Town & Country Planning Act 1990 (as amended)
Town and Country Planning (Development Management Procedure) (England) Order 2015
Approval of details reserved by condition imposed under ref Y/47/18/PL relating to Condition No 3
materials and finishes for external walls and roofs.
Land adjacent 1 Holkham Cottages Burndell Road,,

Arun District Council have decided to **APPROVE details reserved by this condition**

Proposed Elevation

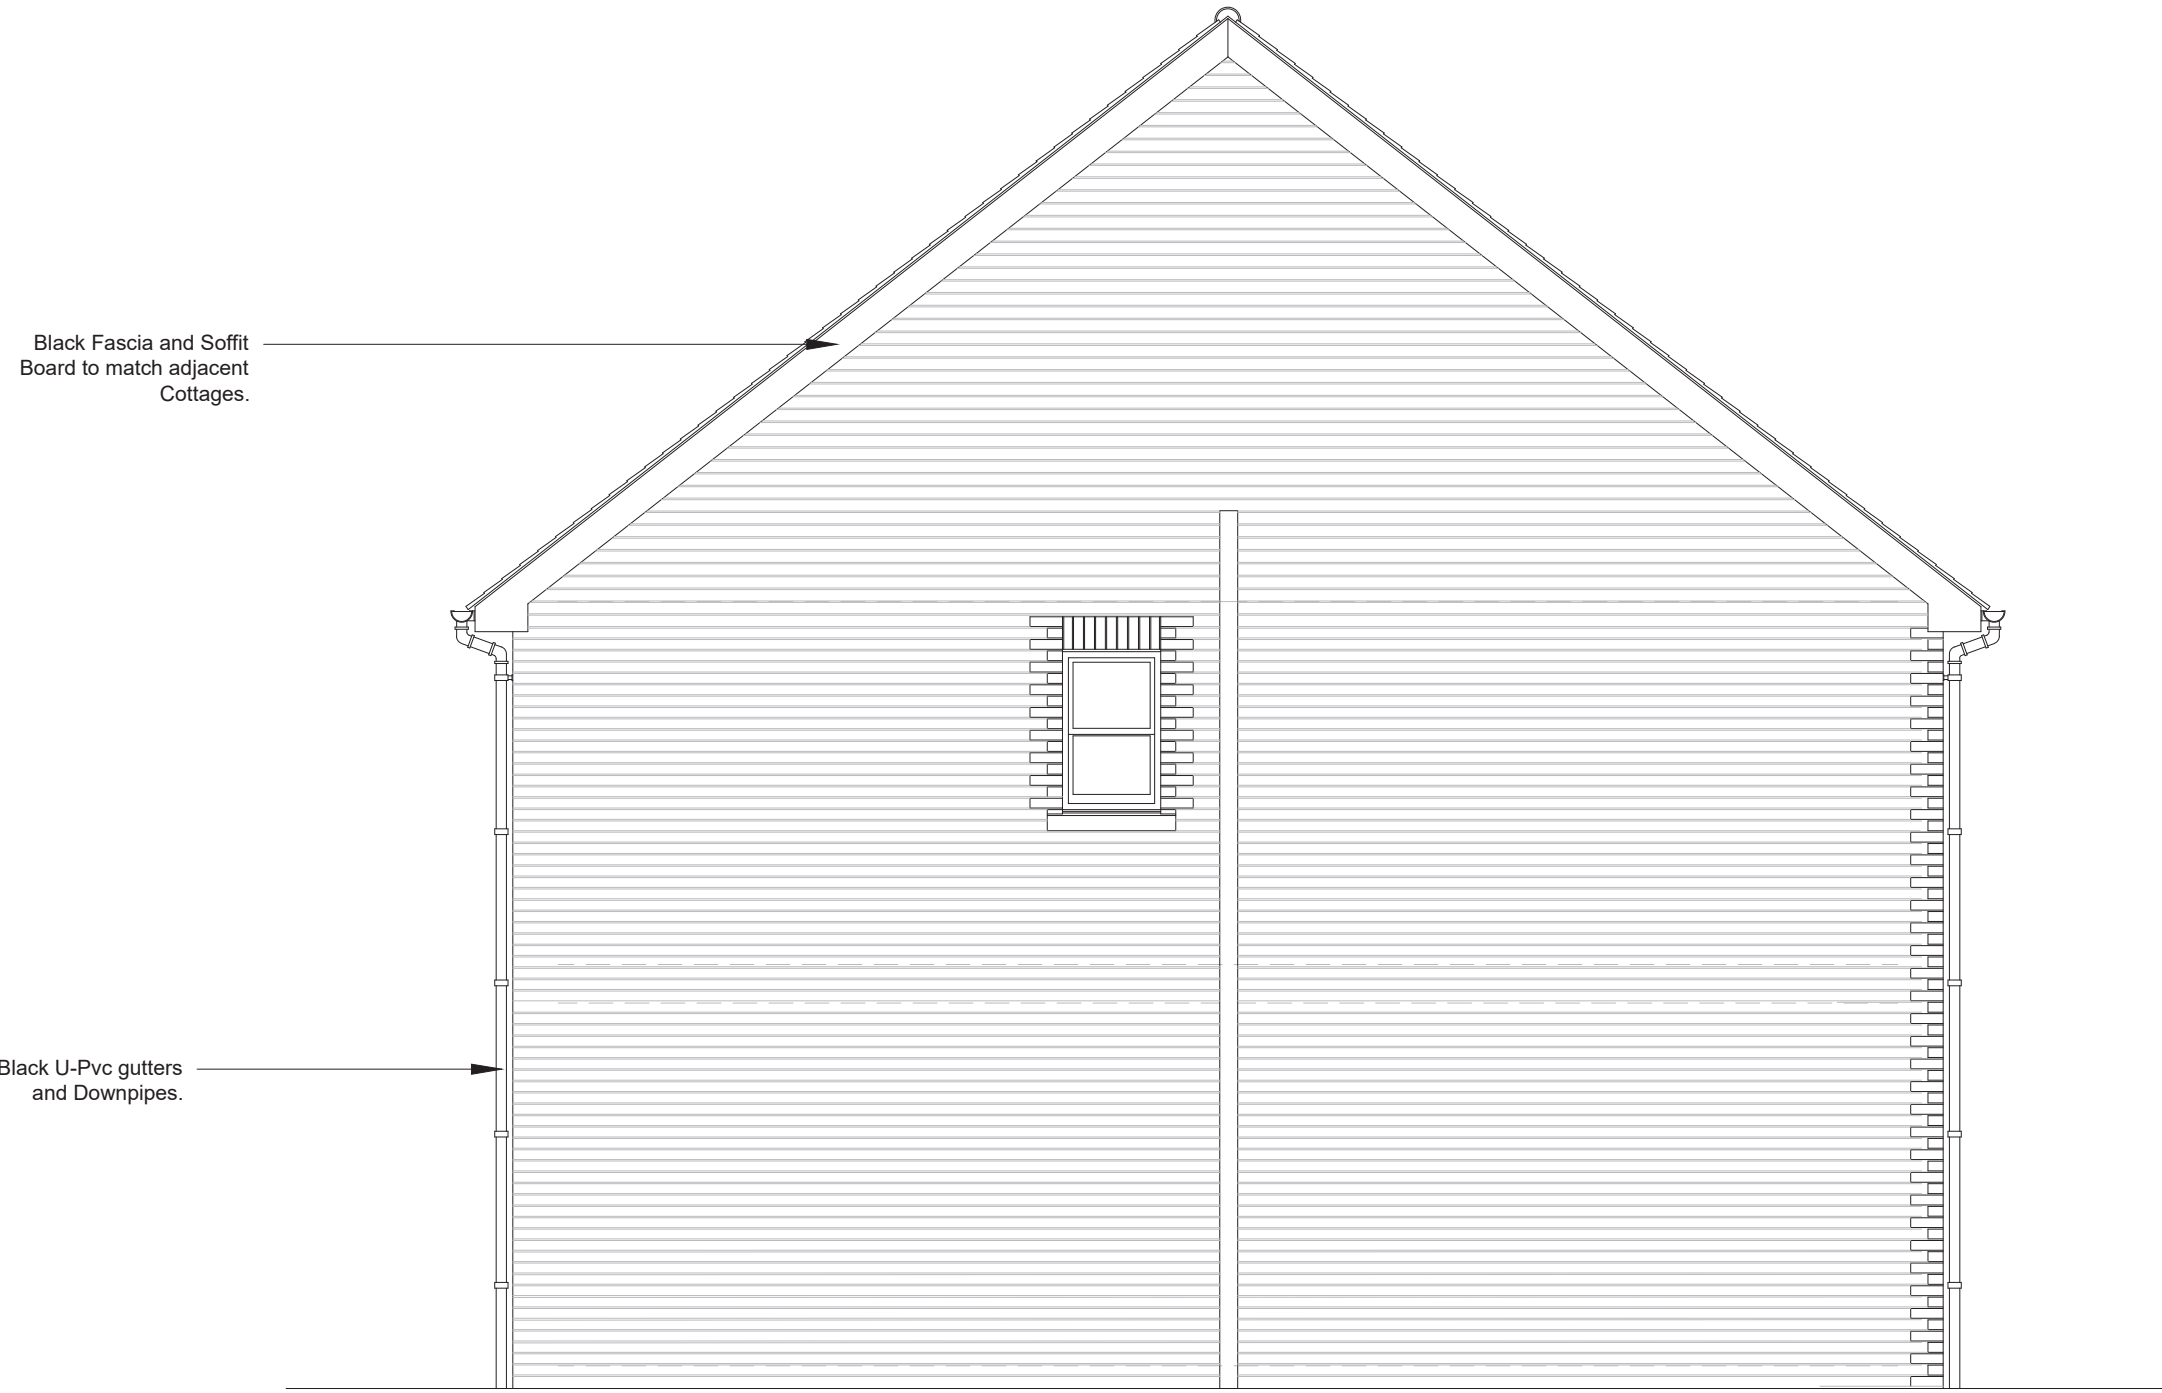
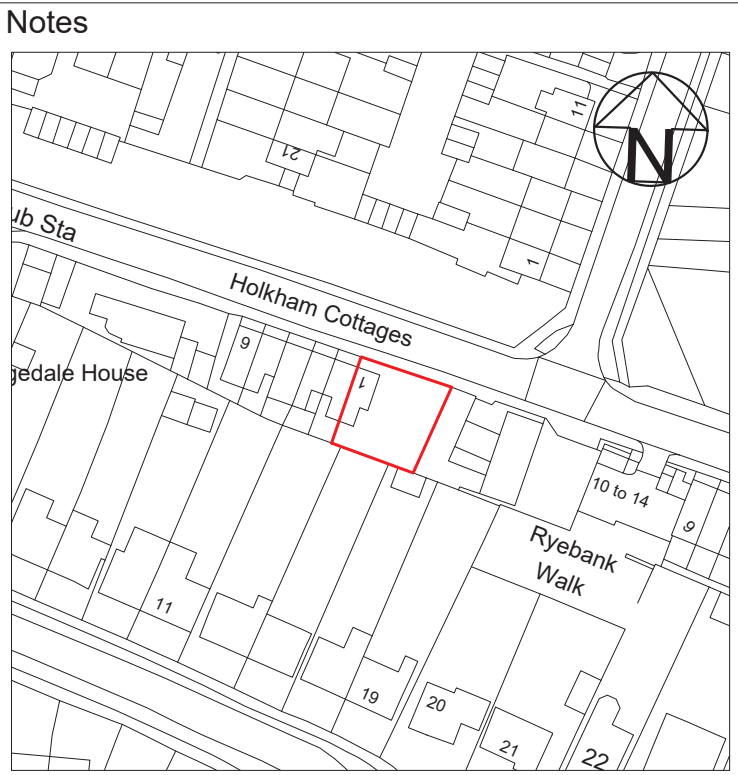
- 1) Main brick - Ibstock Collington Blend
- 2) Contrasting brick - Berkshire Orange Stock Clay facing
- 3) Roof tiles - Sandtoft Plain tile, Rustic

as shown on submitted drawings

- Schedule of materials conditions matrix with Appendices submitted 01.02.2019.
- Proposed elevation 2018/0044-03 Rev A date 20.08.2018
